Department of Planning, Housing and Infrastructure (Major Projects)

Your reference: SSD-68013714

**State Significant Development – EIS & DA Exhibition – Warehouse or Distribution Centre
43 Turner Road Gregory Hills NSW 2557, 14//DP28024, 15//DP28024, 16//DP28024**

1 SITE PLAN
1 : 750

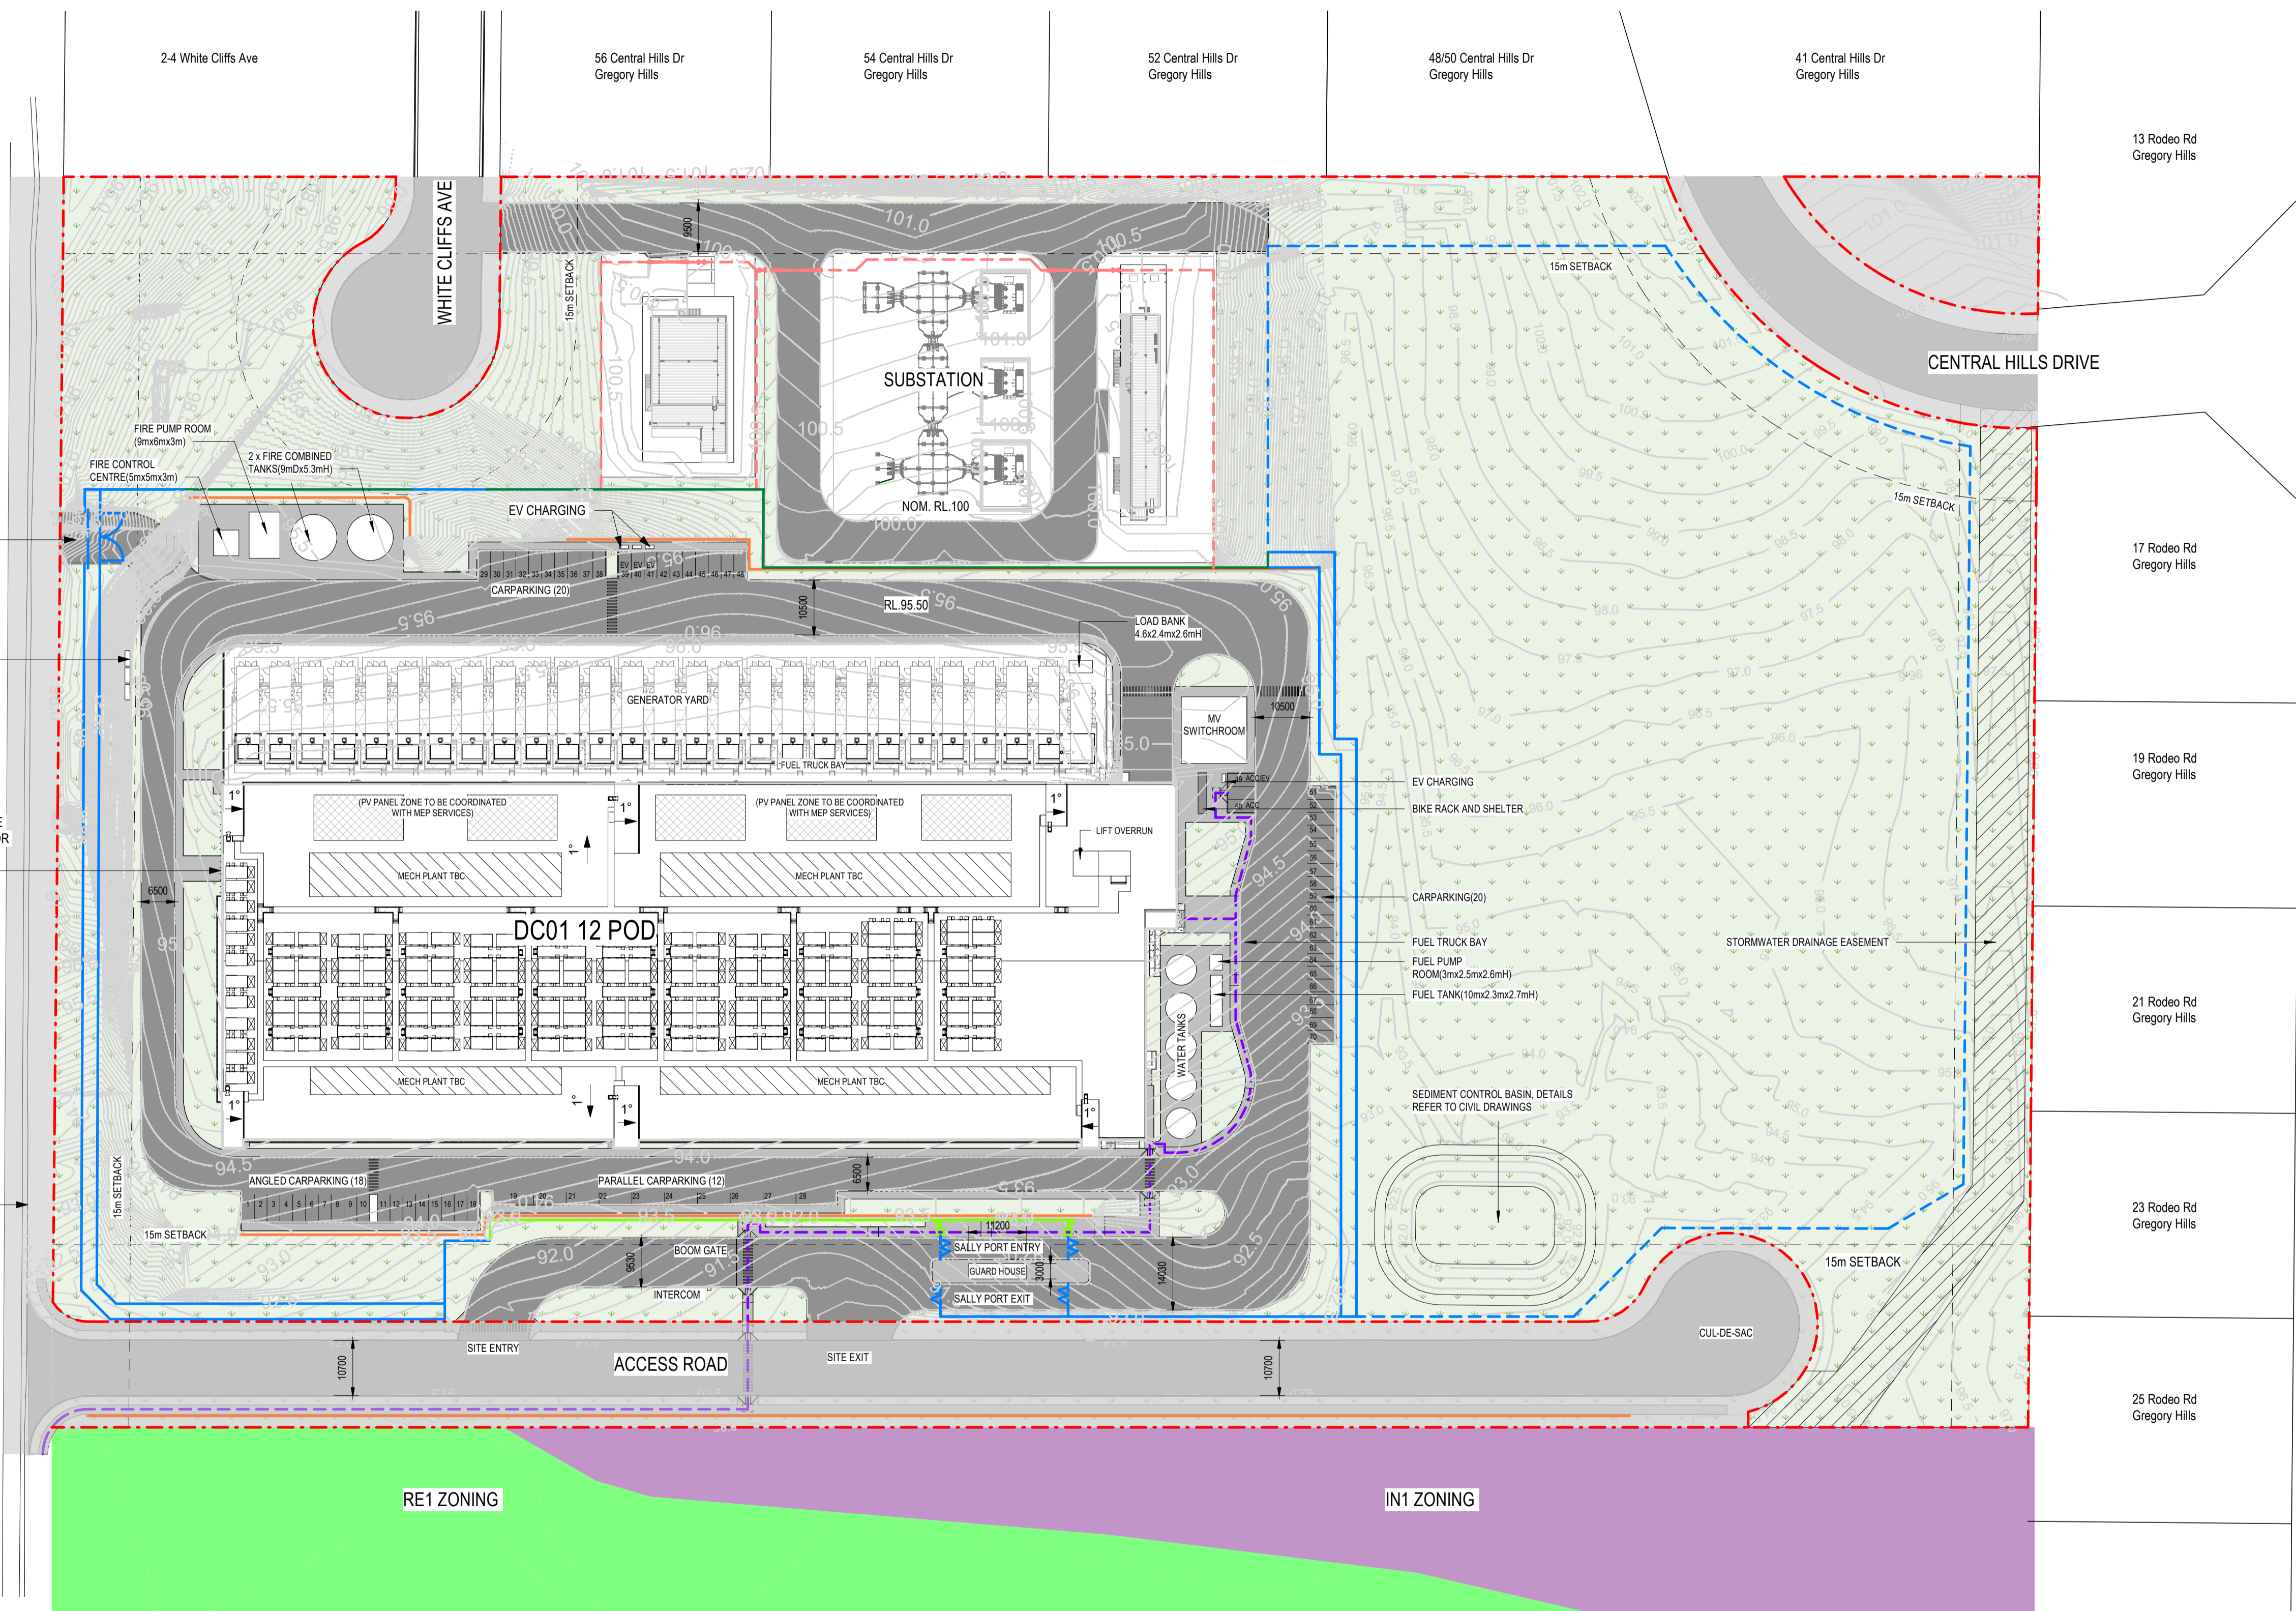
1. From the commencement of building works and in perpetuity, the property around the dwelling must be maintained as an inner protection area to the following distances and aspects in accordance with the following requirements of Appendix 4 of *Planning for Bush Fire Protection 2019*:

- northeast for a distance of 16 metres; and
- all other directions to the property boundary.

- a minimum 1 metre wide area (or to the property boundary where the setbacks are less than 1 metre), suitable for pedestrian traffic, must be provided around the immediate curtilage of the building;
